PLANNING BOARD REPORT PORTLAND, MAINE

Mixed Use Development at 321 Commercial Street

Project ID 2012-615

Submitted to: Portland Planning Board Public Hearing Date: January 22 nd , 2013	Prepared by: Jean Fraser, Planner Date: January 18 th , 2013 Planning Board Report # 02-13
---	--

DATE: 10-22-12
SCALE: 1"=20'
DRAWN BY: BJ5
C04
SHEET: 4 OF 14

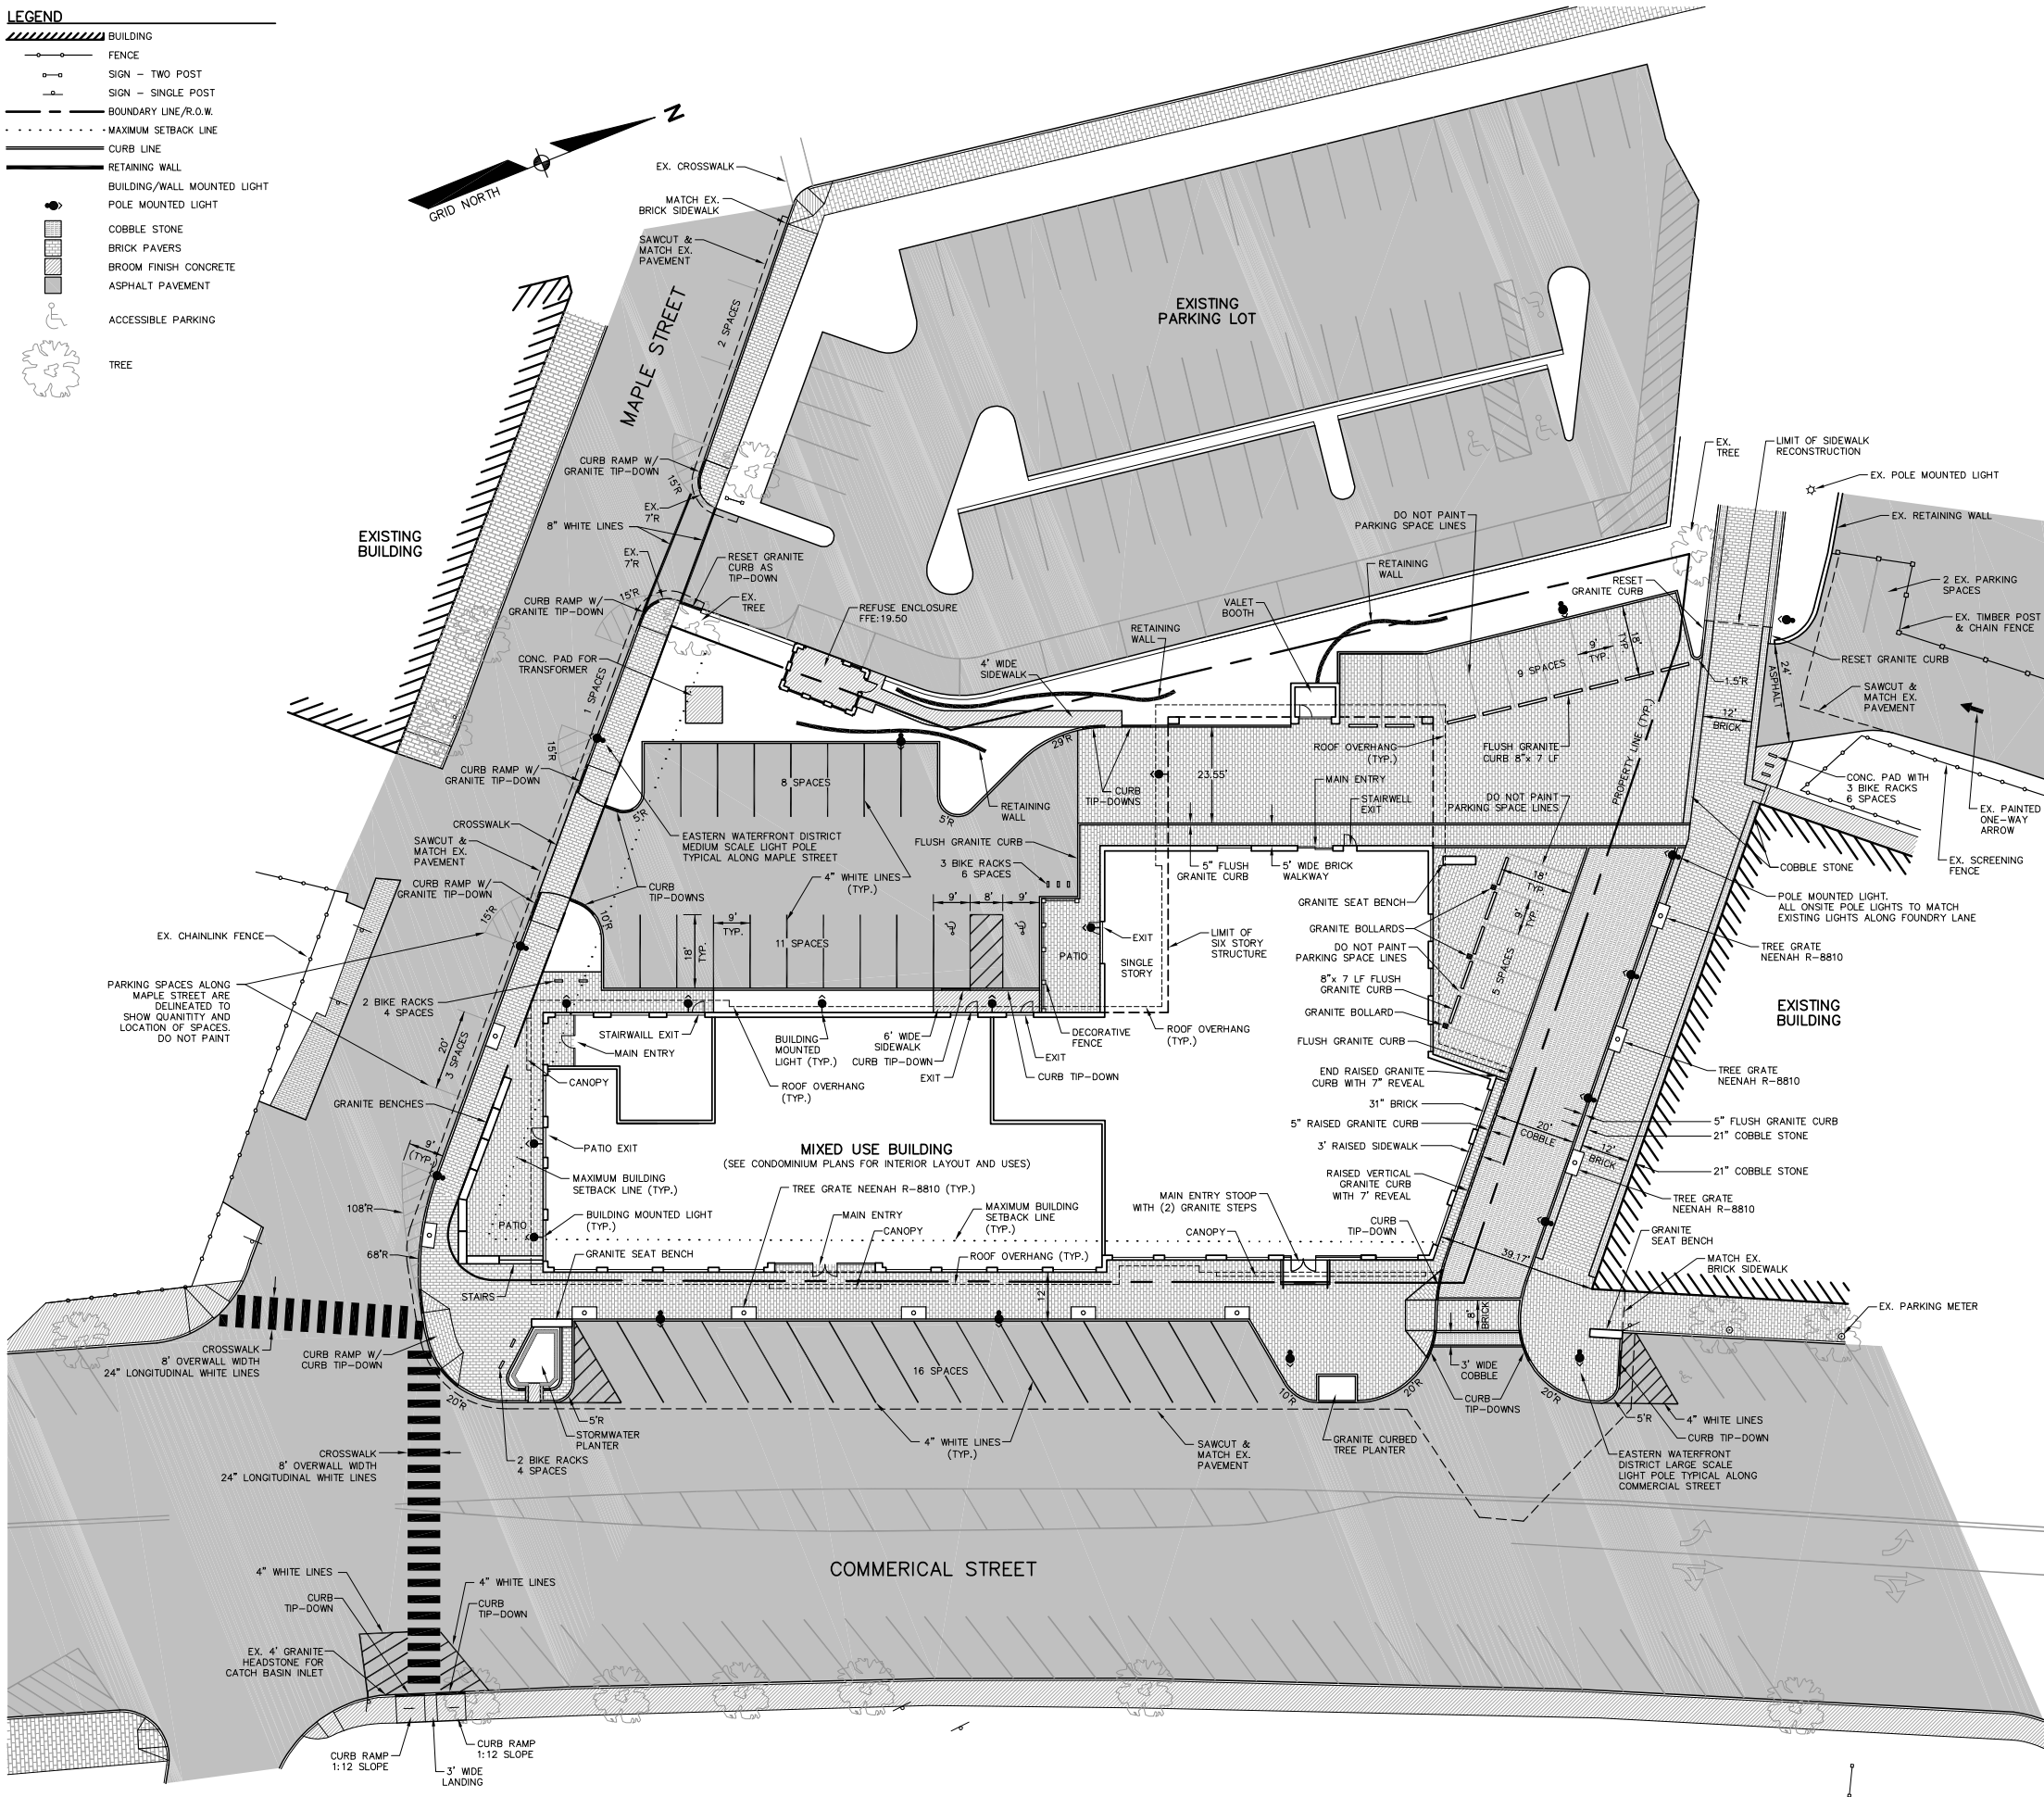
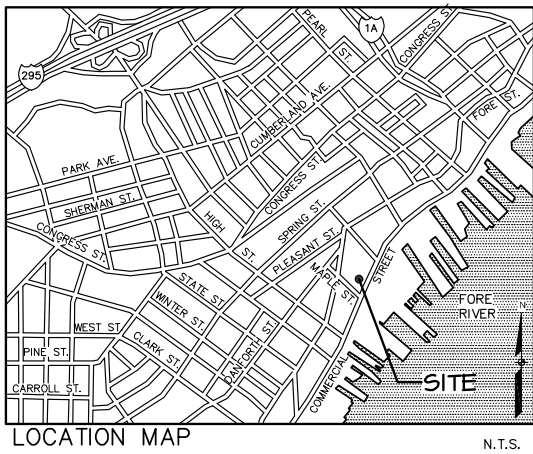
Parking Lot Design: Aisle width to allow a 20 ft width as shown on Sheet C04 in <u>Plan 5</u> , as the aisle is the drive access that has been agreed at 20 ft to allow for a 12 foot wide pedestrian path along the Baxter building.	<i>Technical Manual Section 1.14</i> Parking Lot design shall conform to Figures I-28 thru I-32, which indicate that a 24 foot aisle is required for 90 degree parking.
Site Lighting: Illumination Levels and Light Trespass to allow localized highs up to 9.0 foot candles in approximately 10 locations under wall mounted lights and two small areas of trespass along the west boundary.	<i>Technical Manual Sections 12.2.3 Illumination Levels and 12.2.5 Light Trespass</i> which specify a maximum illumination level of 5.0 foot candles within the site and a maximum of .1 foot candle at the property line.

Mr Errico has supported the requested waivers for driveway separation on Maple Street, the width of the 5-space parking aisle near Foundry Lane, and the reduced sightlines for the proposed crosswalk across Commercial Street.
